CITY OF ALBUQUERQUE

September 4, 2018

Re: Yale Apartments
2017 Yale SE Albuquerque NM 87106
Traffic Circulation Layout
Engineer's/Architect's Stamp **05-07-18** (L15D022)

Based upon the information provided in your submittal received 08-31-18, the above referenced plan cannot be approved for Building Permit until the following comments are addressed:

TRAFFIC CIRCULATION PLAN

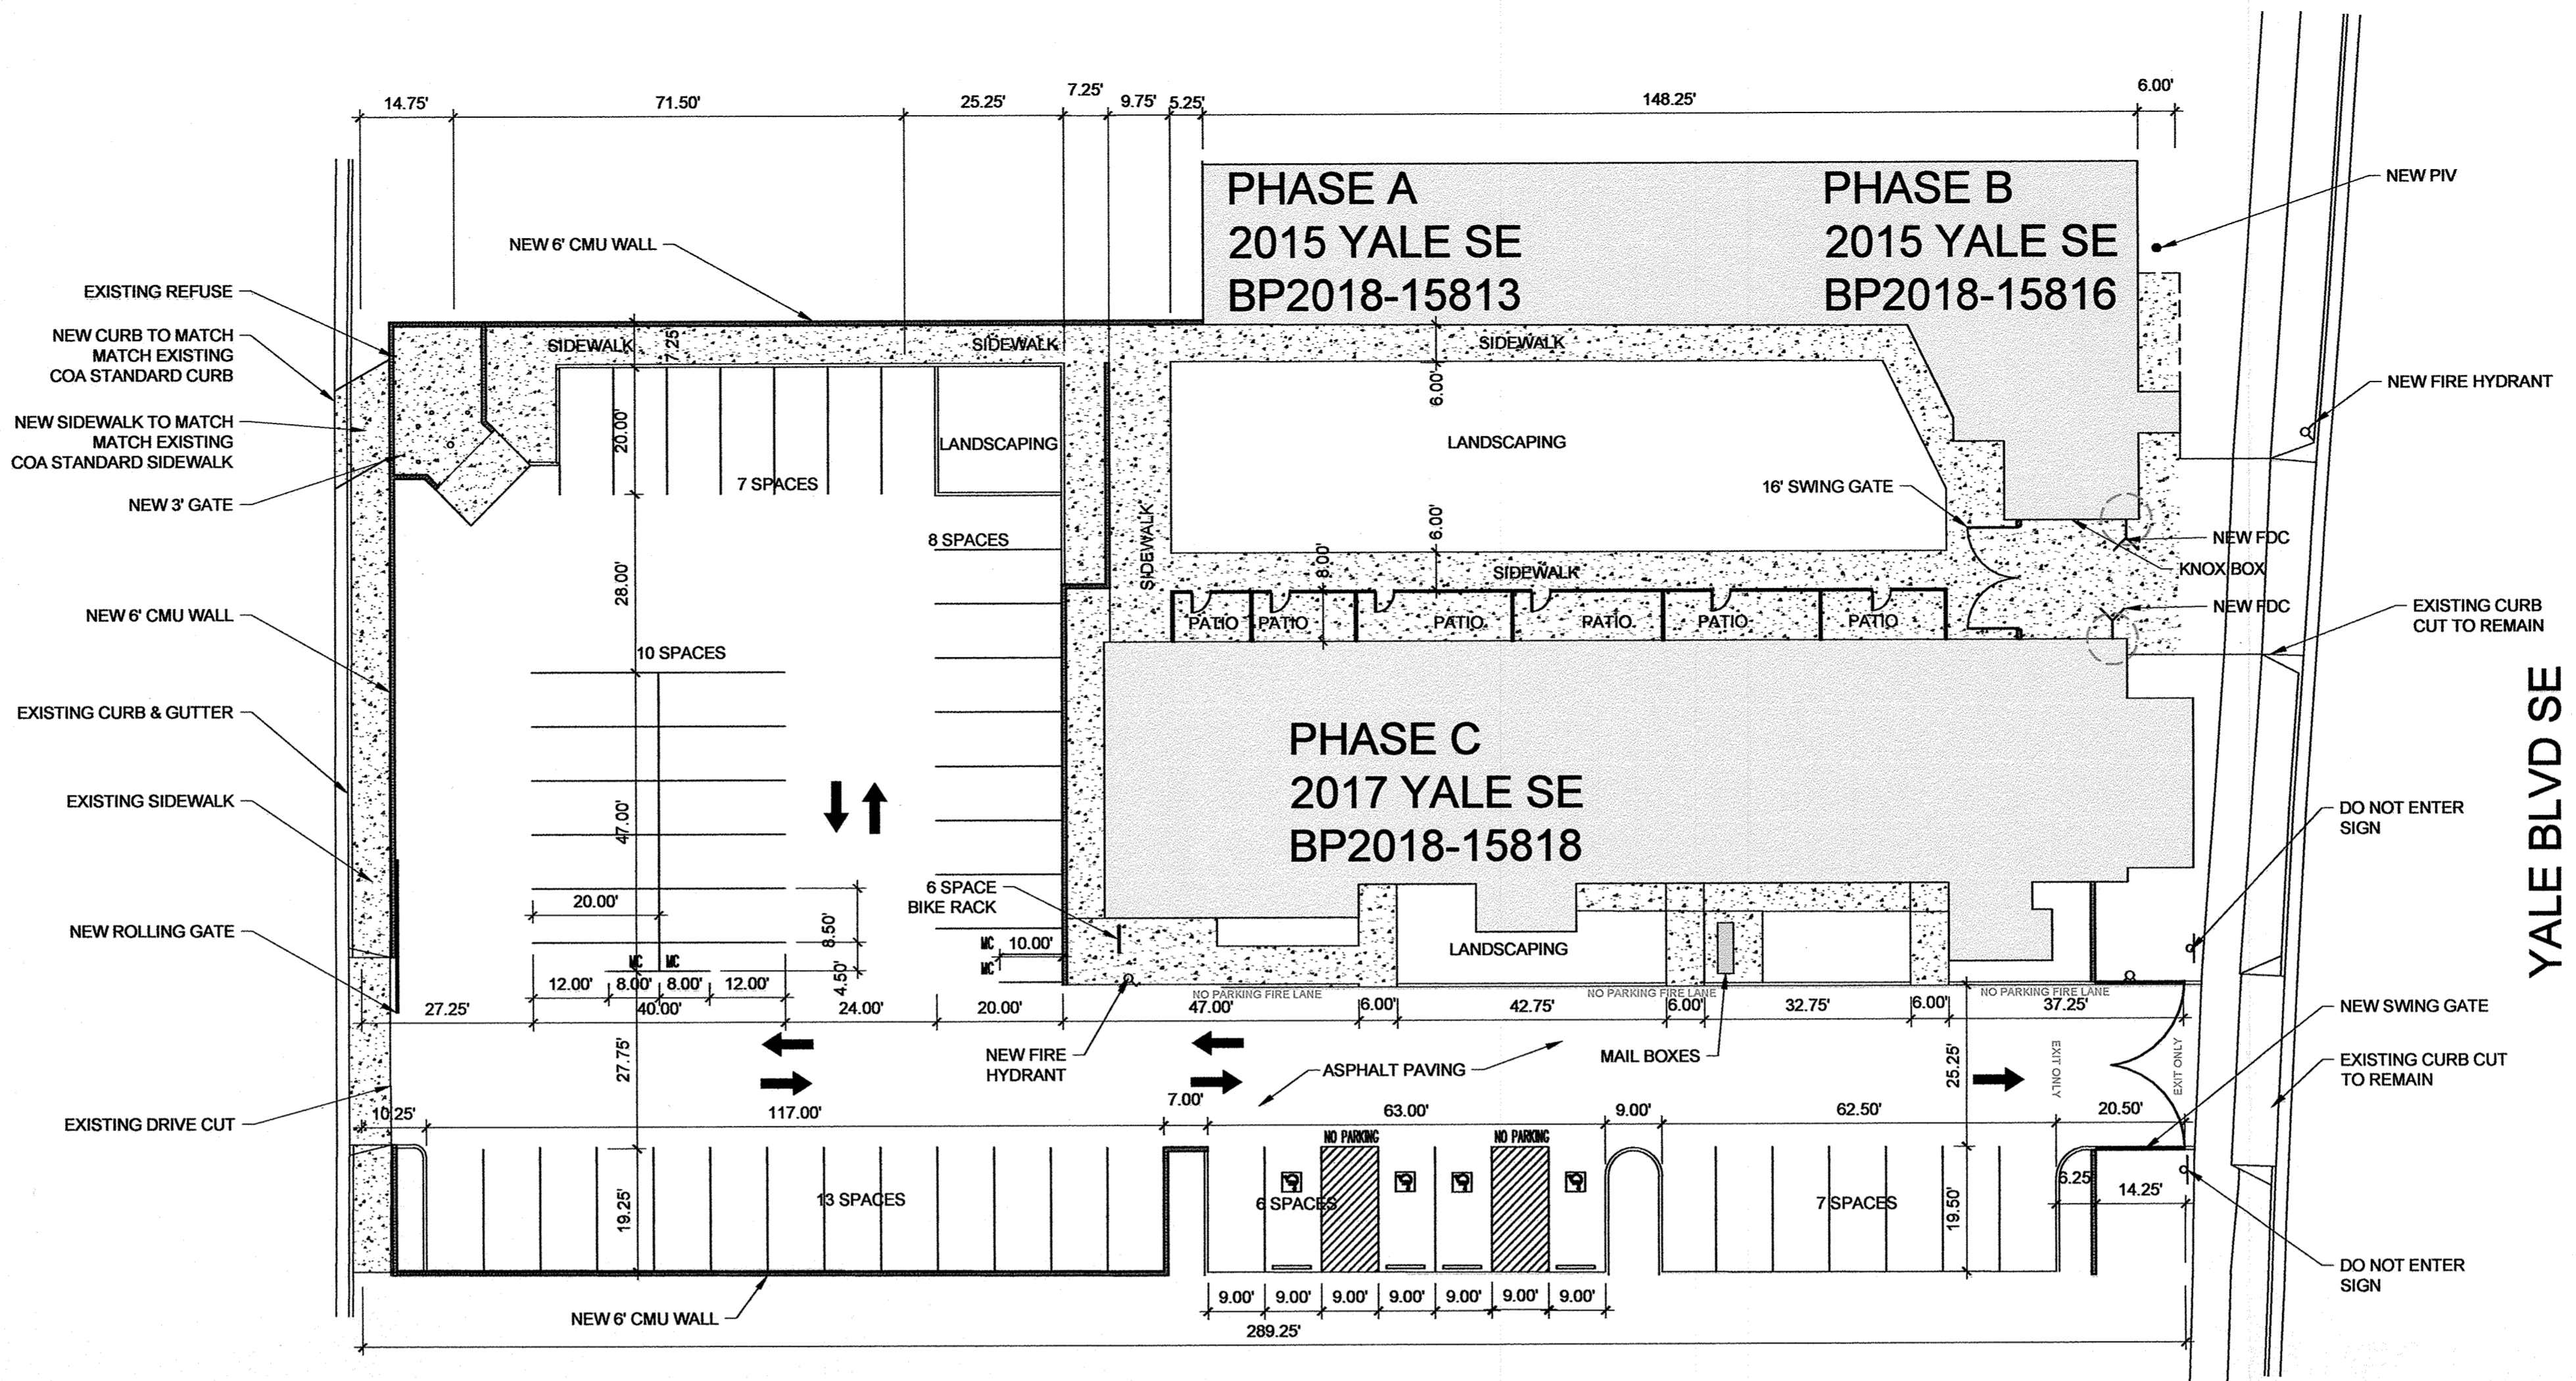
1. The handicap accessible spaces must include an access aisle. Van accessible aisles should be 8ft wide; all others should be 5ft wide. The measurements are not shown on TCL.

2. One-way vehicular paths require pavement directional signage and a posted "**Do Not Enter**" sign at the point of access. Please show detail and location of posted signs.

3. Unused curb cuts must be replaced with sidewalk and curb & gutter. A build note must be provided referring to the appropriate City Standard drawing.

4. Motorcycle parking space should be located somewhere close to the entrance.
5. Service vehicle and/or refuse vehicle maneuvering must be contained on-site.

6. Provide information regarding the pedestrian access to the Phase A, and Phase B units from west parking lot.
7. Clarify the rectangular spaces at the north side of the phase C units.

BIKE RACK

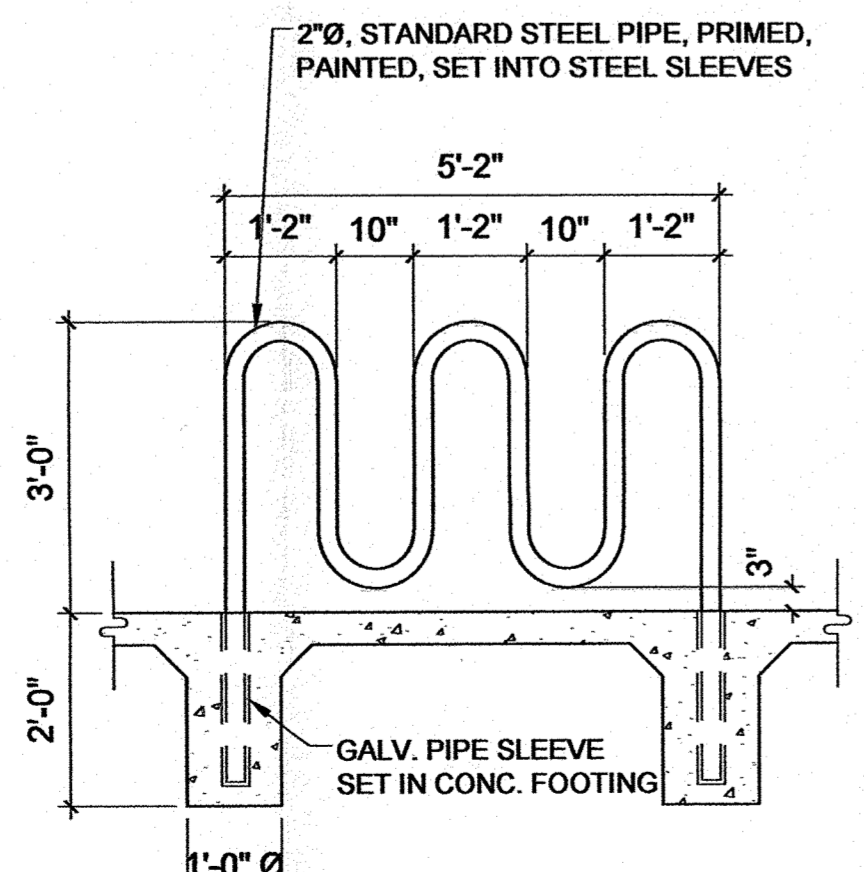
8. Relocate the bike rack to the end of the landscaping area. Bike rack can not be located in the middle of the landscaping area.
